Your Ref: OWPC20996
Our Ref: FG/220/18/PL 17-12-2018
Please ask for:
Andrew Wood

Erection 1 No. dwelling with integral garage.
Land adjacent to Elm Lodge Tamarisk Way Ferring

Thank you for your internet representation made on 4th January 2019 which has been recorded as '**an objection**' with the comments as follows:

PROPOSED ROOF PLAN AND
PROPOSED ELEVATIONS

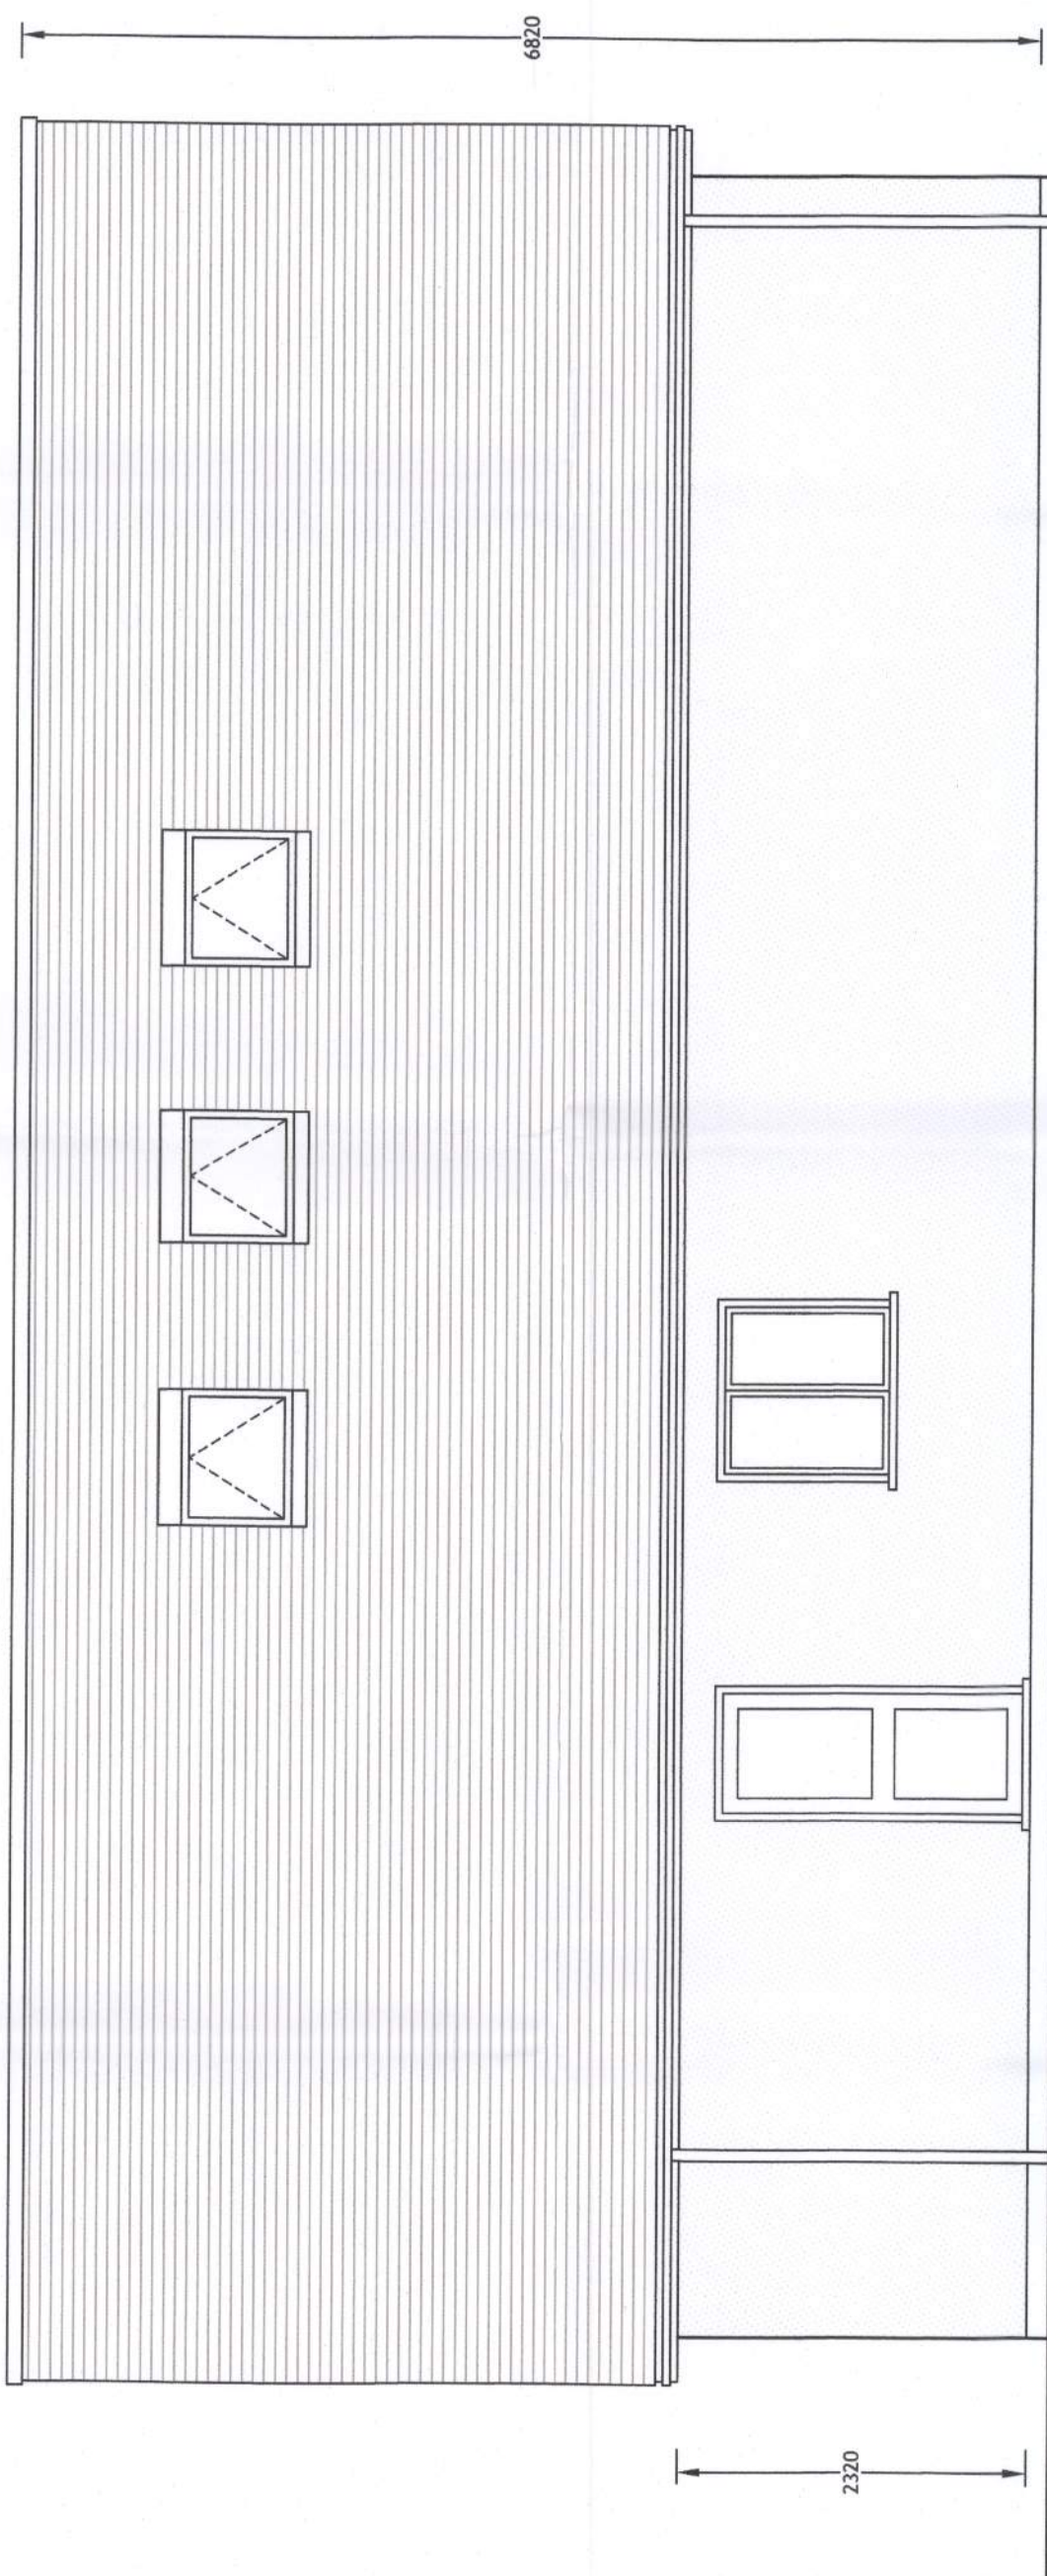
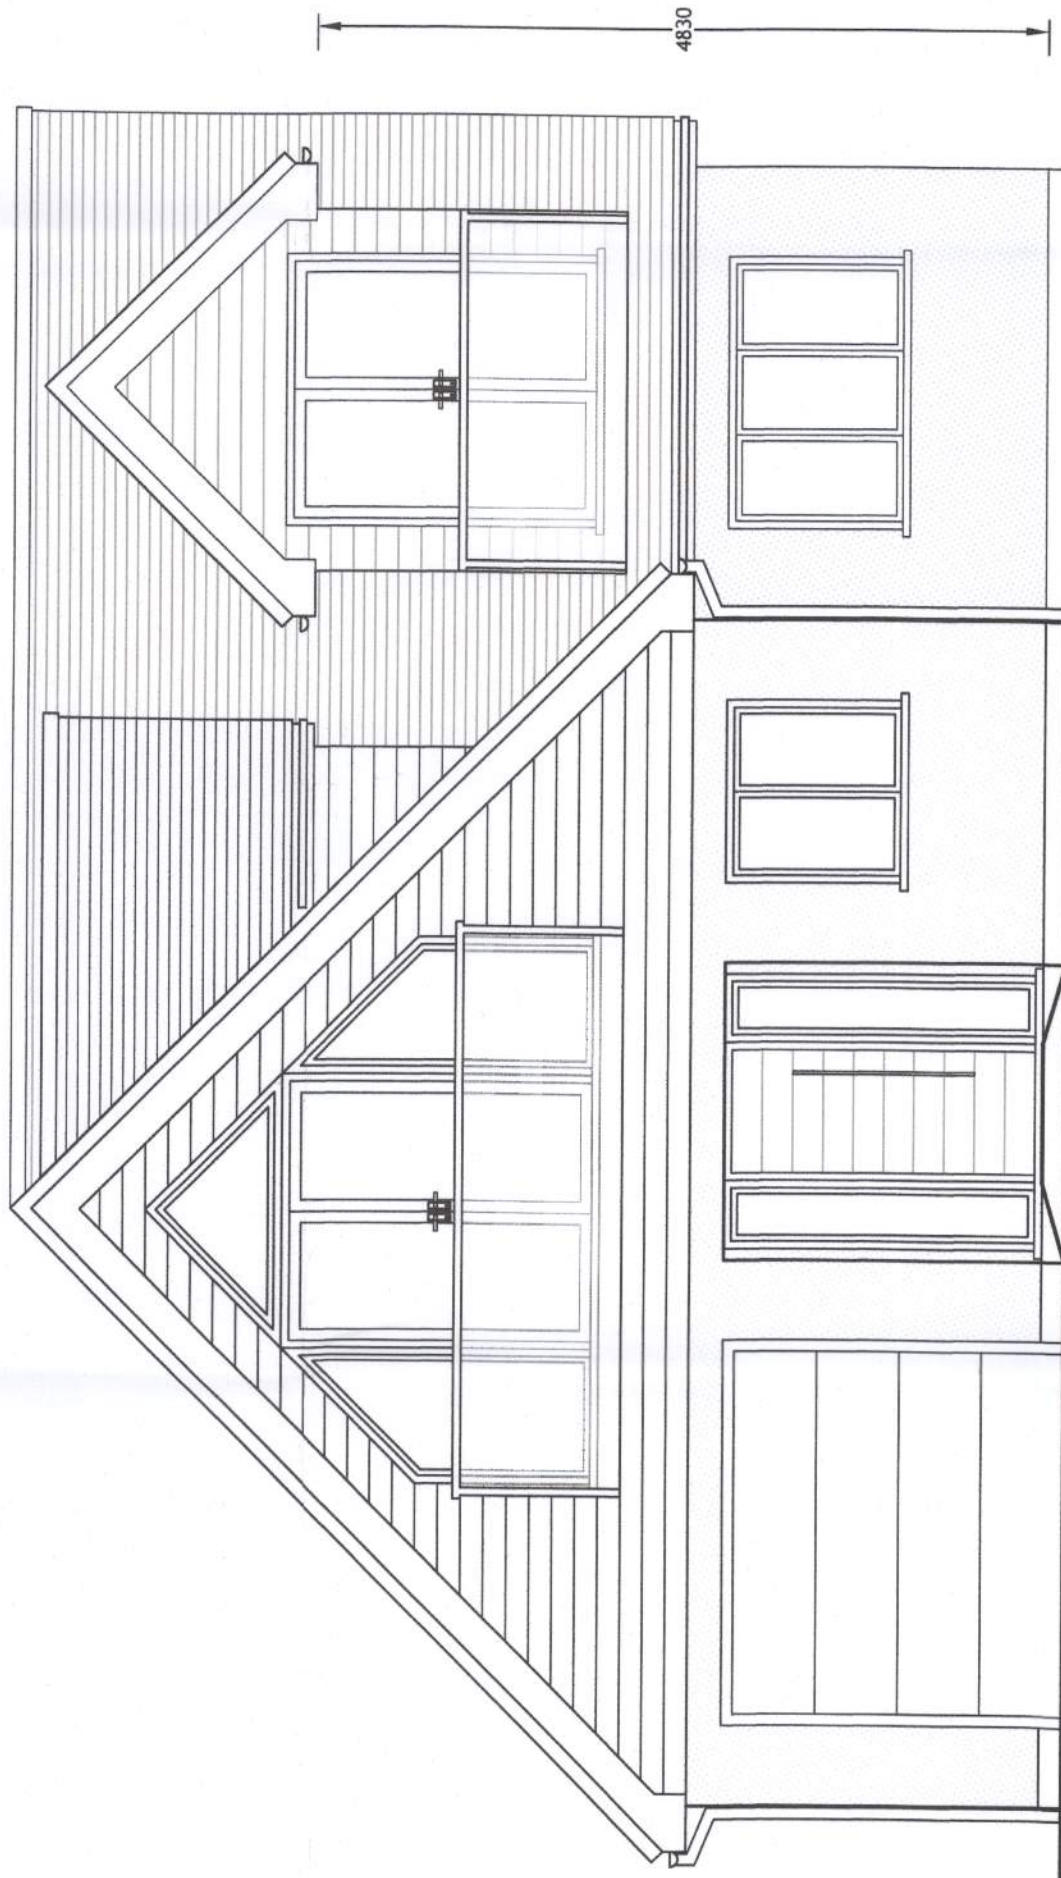
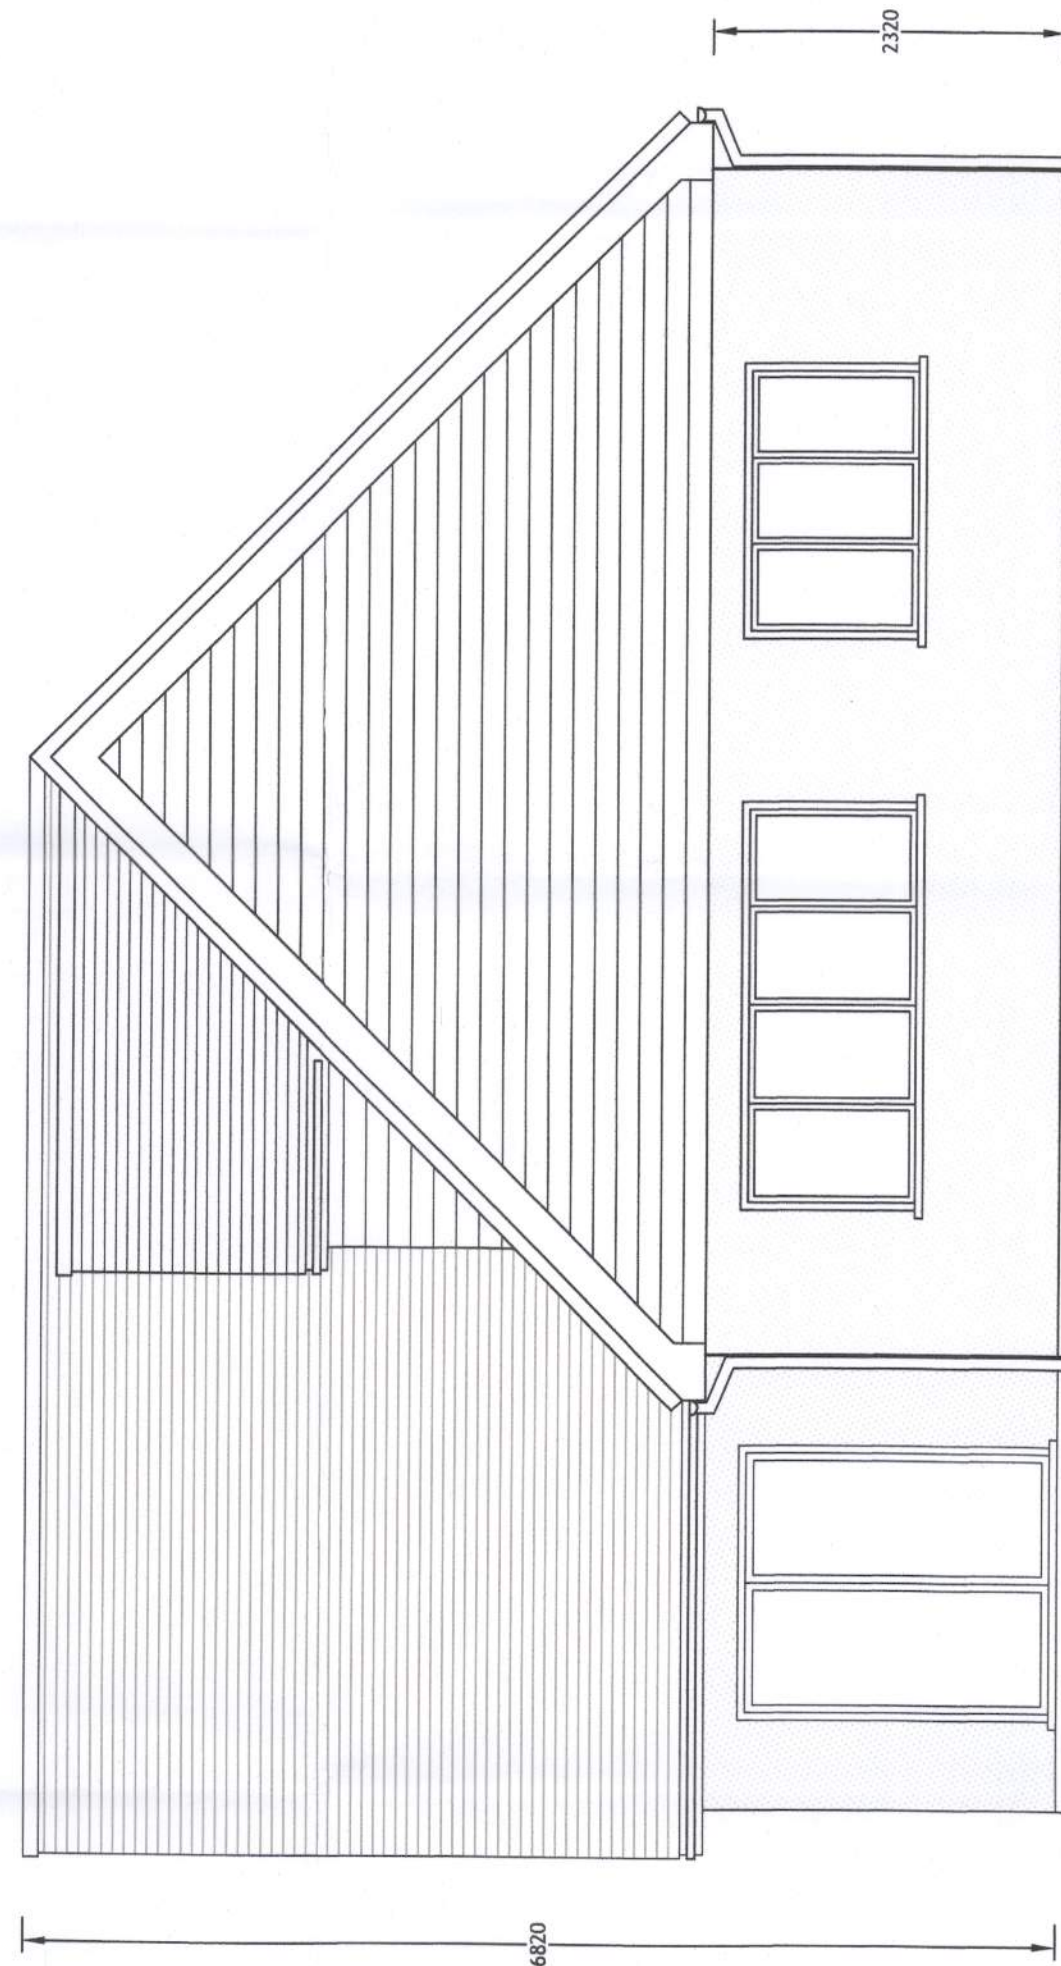
2 The style of the dwelling proposed and in particular the modern materials to be used does not in any way integrate with the appearance of the street's 1930s bungalows and in particular the house opposite, a mirror image of Elm Lodge and its garden.

3 We object to the 2 large modern balcony windows which directly overlook the entire garden of Magalia, removing all elements of privacy.

Drawing Title **PROPOSED POND ACCESS
PLAN**

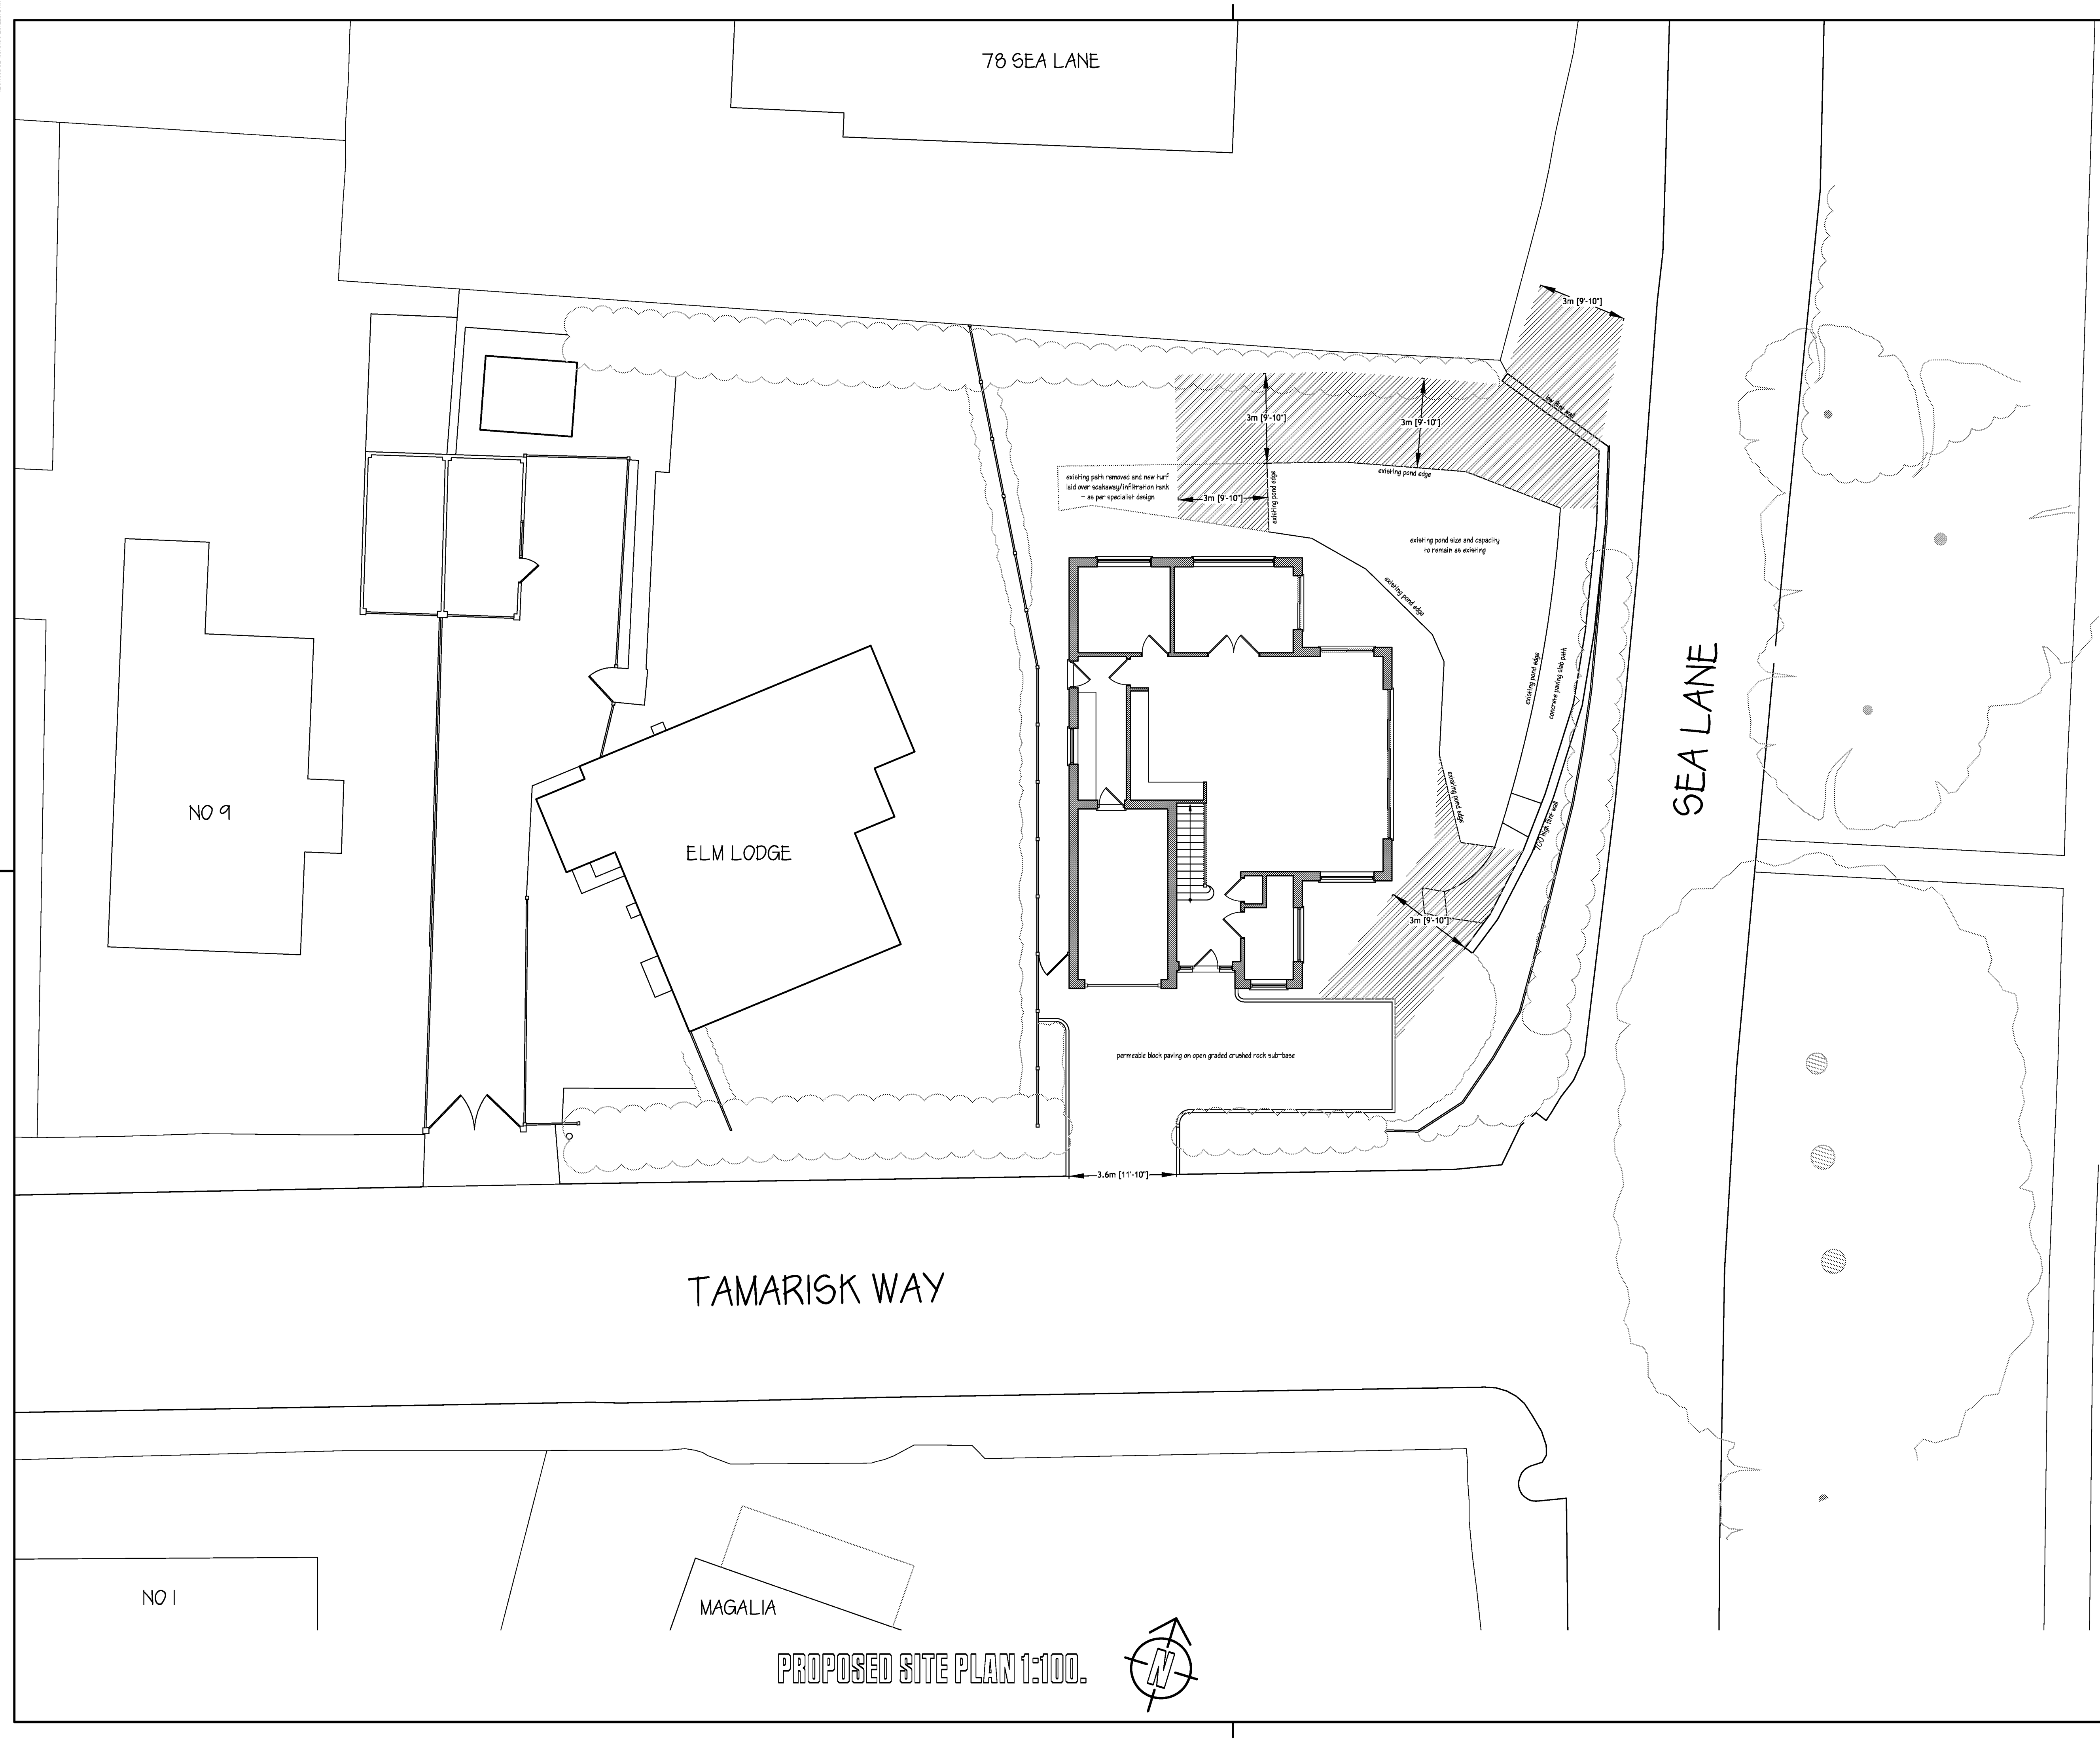
4 The pond forms an integral part of the surface water drainage system in South Ferring, and any reduction of its size combined with additional run off water from the proposed property could seriously increase the risk of flooding.
